WEST SUSSEX COUNTY COUNCIL CONSULTATION

TO:	Arun District Council FAO: Amy Myer
FROM:	WSCC - Highways Authority: Tim Townsend
DATE:	12th March 2020
LOCATION:	Land Adjacent to Highfield House Yapton Road Barnham PO22 0AZ
SUBJECT:	BN/128/19/OUT Application for Outline Planning Permission for development of 70 bed Care Home and 14 Assisted Living Bungalows with associated car parking, landscaping and access - Departure from the Development Plan. Stage 1 Road Safety Audit and Designer's Response provided.
DATE OF SITE VISIT:	3 rd March 2020
RECOMMENDATION:	More Information
S106 CONTRIBUTION TOTAL:	Non-highways to be provided separately. Highways TBA.

This is the second WSCC County Highway Authority (CHA) response to the above planning application for outline Planning Permission for development of a 70 bed Care Home and 14 Assisted Living Bungalows with associated car parking, landscaping and access - Departure from the Development Plan.

DATE  
JULY 2019  
JOB / DRWG No  
1693 / SP1

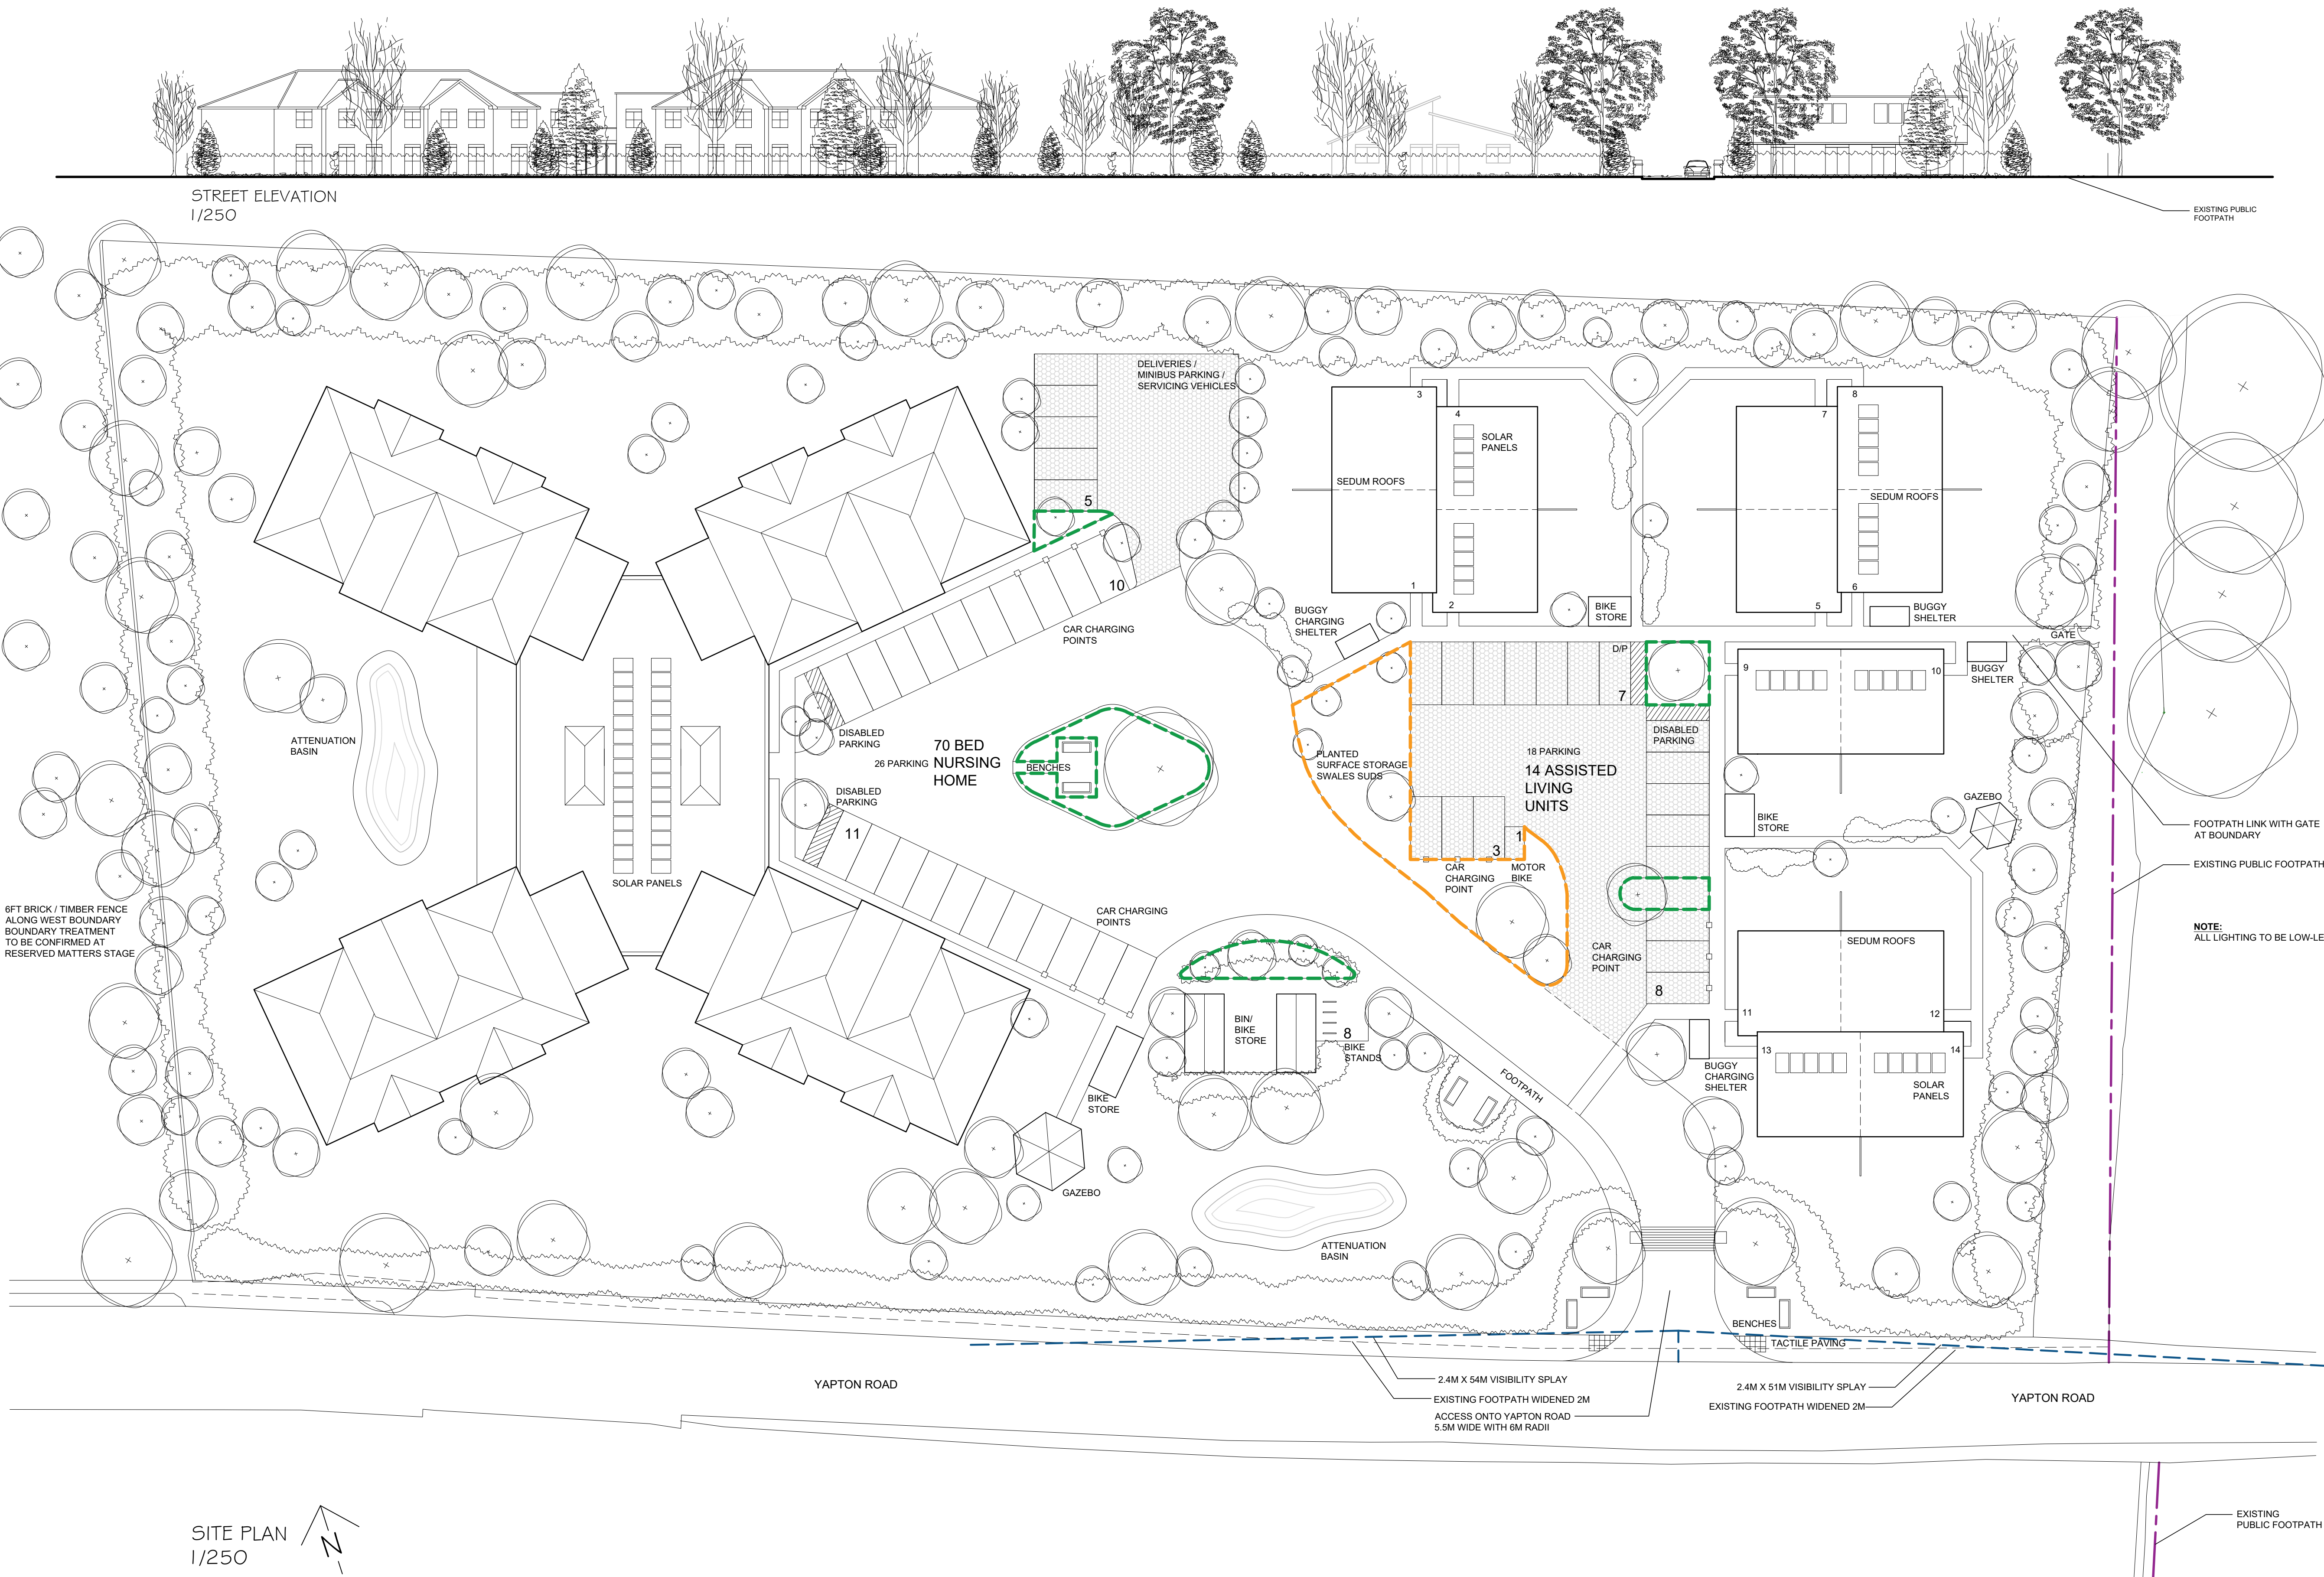
While the internal access arrangements would not be eligible for adoption, it is observed that the footway shown entering the site narrows where it meets the first 'bank' of parking spaces adjacent to part of the care home. As part of any detailed design, it is recommended that a minimum width of 1.5m is provided for any continuation of a path into the care home if it is intended to run behind the parking spaces. If the intention is to provide a shared-arrangement for users using the access 'road', then adequate markings, pram ramps, tactile paving should be provided.

Non-motorised access to the assisted living units would rely on residents sharing the vehicular access. While shared-space arrangements are common, provision should be made to ensure that residents will have a suitable place to cross the internal access 'road' to reach the units (i.e. pram ramps, tactile paving and visibility splays). Furthermore, 1.0m-wide strips should be provided behind and to the side of the parking spaces for these units to give a place to board and alight without having to stand on

grassed or other soft-landscaped areas. The 1.5m wide paths should also be provided here.

With regard to the layout of the parking (and access) area, this appears to generally comply in terms of space sizing and circulatory provision for refuse and other large vehicles. However, at any detailed design stage, the applicant will be required to demonstrate compliance with Building Regulations with regard to fire appliance access – particularly to the buildings in the north-eastern corner of the site and those located in the far-western part of the site. Both appear to exceed the 45m requirement.

Finally on the design of the car parking and again at the detailed design stage, the circulatory area shown for the assisted living units should be extended by 1m westwards to assist with on-site turning and manoeuvring.

Finally on this point, a 2.4m x 2.4m pedestrian intervisibility splay should be provided at the south-eastern corner of the site adjacent to the Public Right of Way (PRoW) for visibility purposes for users.

7. Provision of amended plan showing 2.4m x 2.4m pedestrian intervisibility splay at the south-eastern corner of the site adjacent to the Public Right of Way (PRoW).

Proposed Access
onto Yapton Road

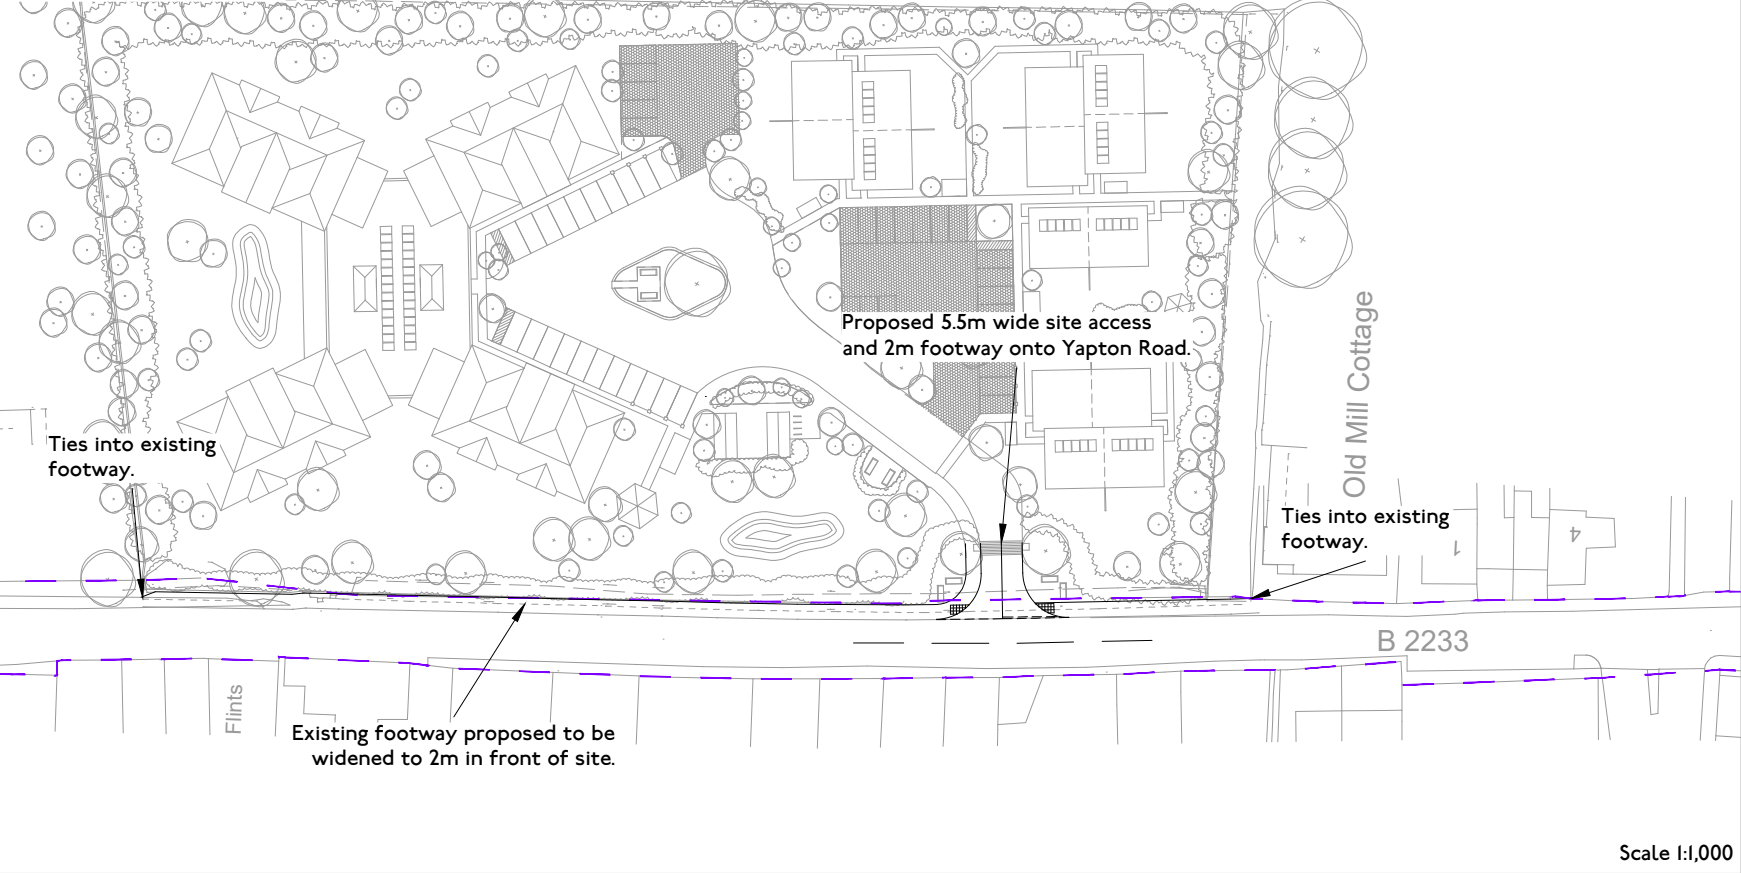
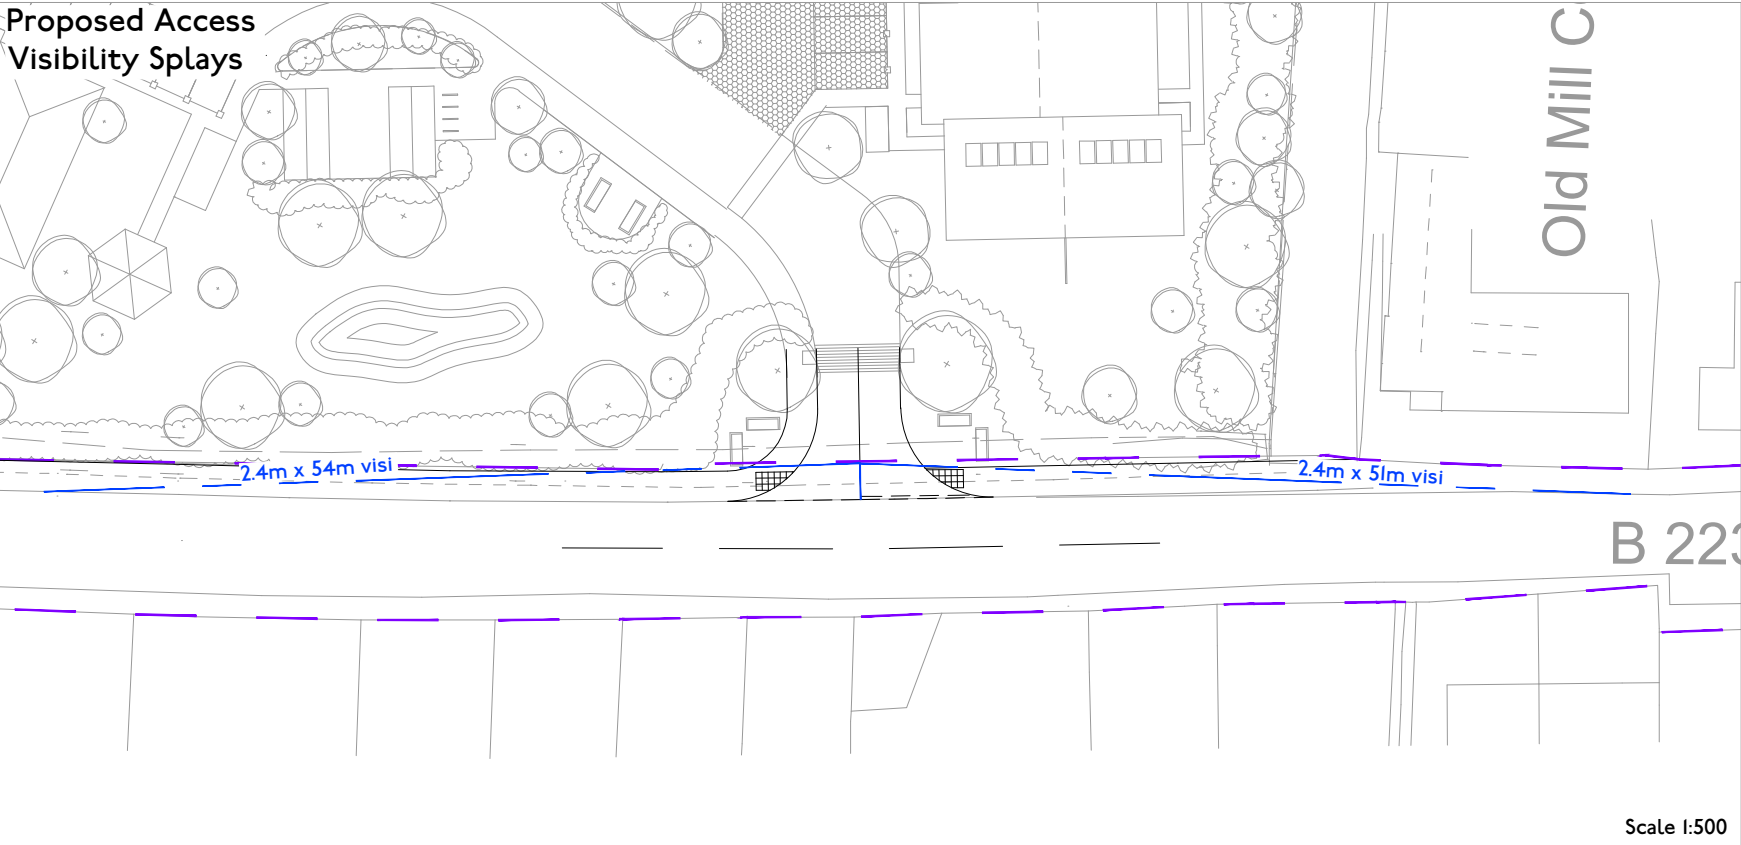
3. Problem - Possible vehicular conflicts in the access (large vehicles coming-across smaller ones). Recommendation - That the access be widened to accommodate all movements to avoid conflicts.

3.1 Potential collisions associated with insufficient road space	Review the layout, it may be more appropriate to widen the access to ensure vehicles can pass each other safely.	The indicative layout is subject to detailed design considerations. Nevertheless, the indicative internal access has been designed to provide additional carriageway width immediately before the access onto Yapton Road. This would provide additional space for a vehicle to wait while a large vehicle such as a refuse vehicle completes its manoeuvre into the site. Furthermore, the majority of predicted vehicle movements for the proposed development are	Agree with Design Organisation. Although the access does still demonstrate some conflict between large and small vehicles when entering and/or leaving the site, the movement of large vehicles such as refuse lorries would be infrequent and given the low to moderate traffic generating capabilities of the site overall, opportunities for conflicting traffic movements would present very rarely and would not be unusual to other examples elsewhere, with	<u>Design Organisation:</u> Overseeing Organisation: That the access remains as generally shown on drawing no. J32-4375-001 for the reasons given in the Overseeing Organisation's response in the preceding section.

likely to relate to smaller vehicle types rather than a large vehicle. The width of the proposed access (5.5m with 6m radii as standard) and internal access (approx. 6m) can comfortably accommodate two vehicles passing each other.	<i>associated low risk to users. Two cars coming-across one-another (i.e. what the majority of users would be travelling in on a daily basis) would not appear to conflict with one-another.</i>

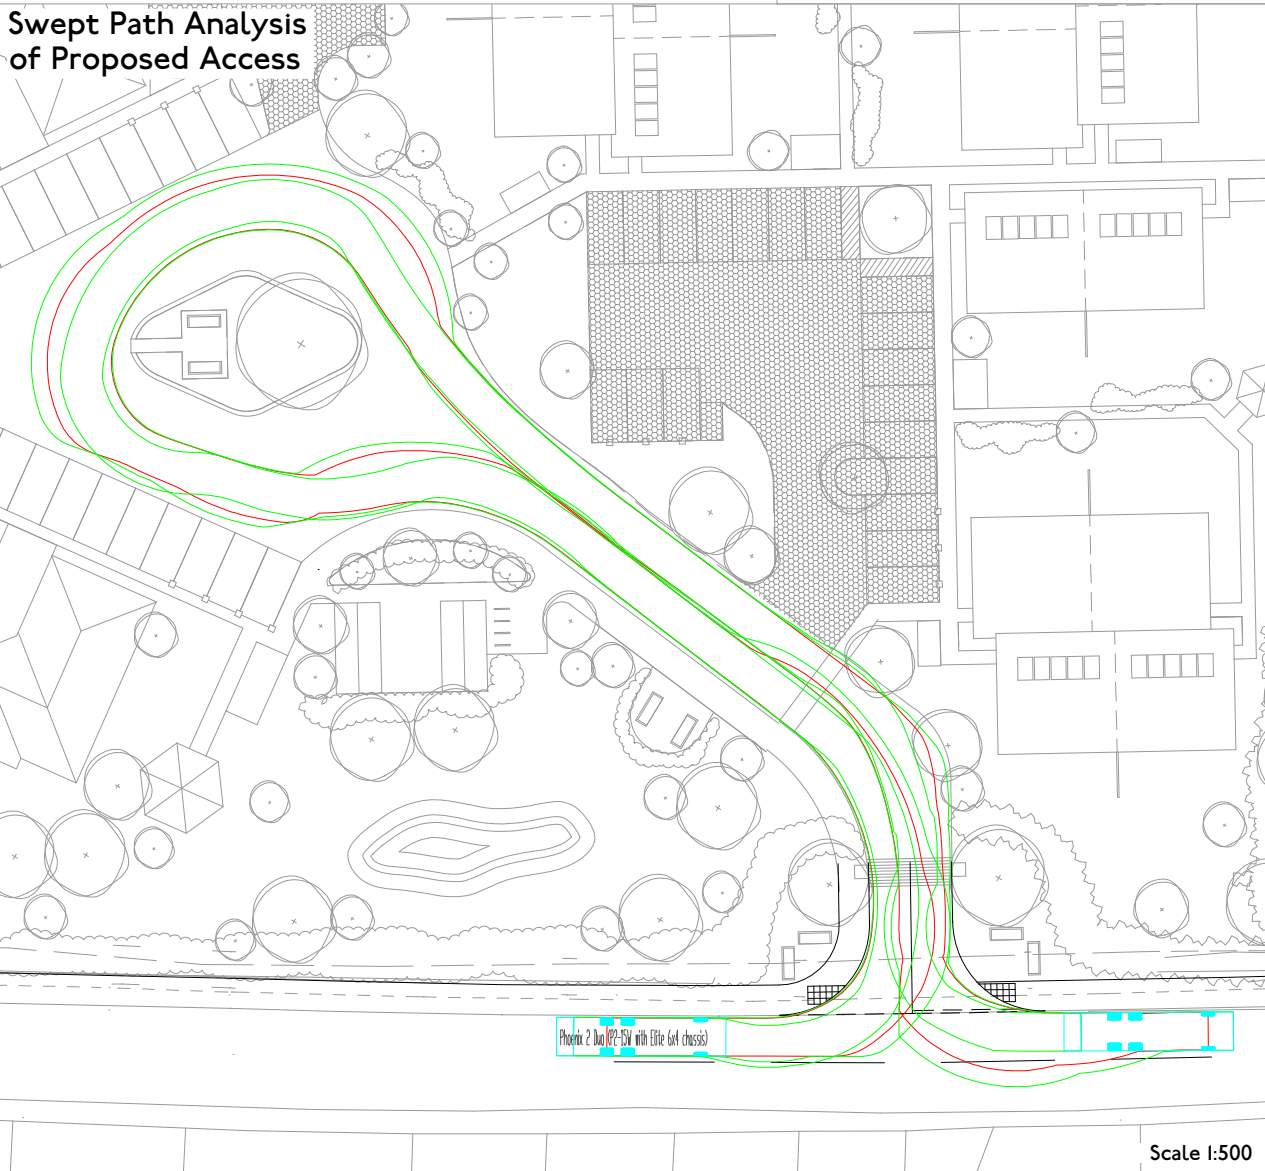
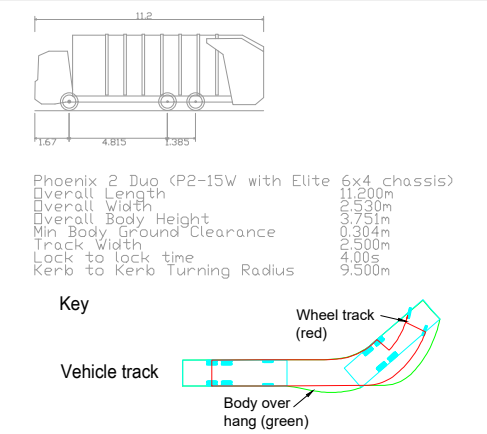
4. Problem - Site access visibility splays and associated maintenance. Recommendation - That the correct splays are provided and maintained with appropriate maintenance provision etc.

3.2 Vehicular collisions associated with poor visibility	Ensure that the existing vegetation adjacent to the visibility splay cut back and regularly maintained or replaced with a low level variety in order to provide good visibility for motorists exiting onto Yapton Road.	The proposed access provides visibility splays of 2.4m by 54m to the east and 51m to the west. These splays are based on recorded 85th percentile speeds, adjusted for wet weather and MfS sight stopping distance calculations. The splays provide sufficient visibility as per the WSCC guidance for the application of MfS calculations on a 30mph road as detailed in their Local Design Guide Supplementary Guidance. Vegetation within the visibility splay will be managed and kept to a maximum height of 600mm.	Agree with Design Organisation. <i>The response to the vegetation maintenance issue is accepted by the Overseeing Organisation. However, further info required from the designer in response to the visibility point raised in the RSA recommendation.</i>	<u>Design Organisation:</u> <u>Overseeing Organisation:</u> <i>That the vegetation is regularly managed and kept to a minimum of 600mm in order to maintain the required sight line splays.</i>

Specifically with regard to point 4 (site access visibility splays), it is not apparent that the Transport Consultant has used the latest standards for determining the necessary visibility splays. CA185 is the correct document and evidence should be provided that (1), it has been used and (2), how the splays shown comply with the Design Standard.

1. The attached Road Safety Audit 'log' to be updated by the designer ('Design Organisation') in accordance with the comments made above.
2. Provision of further information relating to visibility requirements and demonstration by the applicants/the designer that the sight line splays are compliant with DMRB standards contained in CA185.
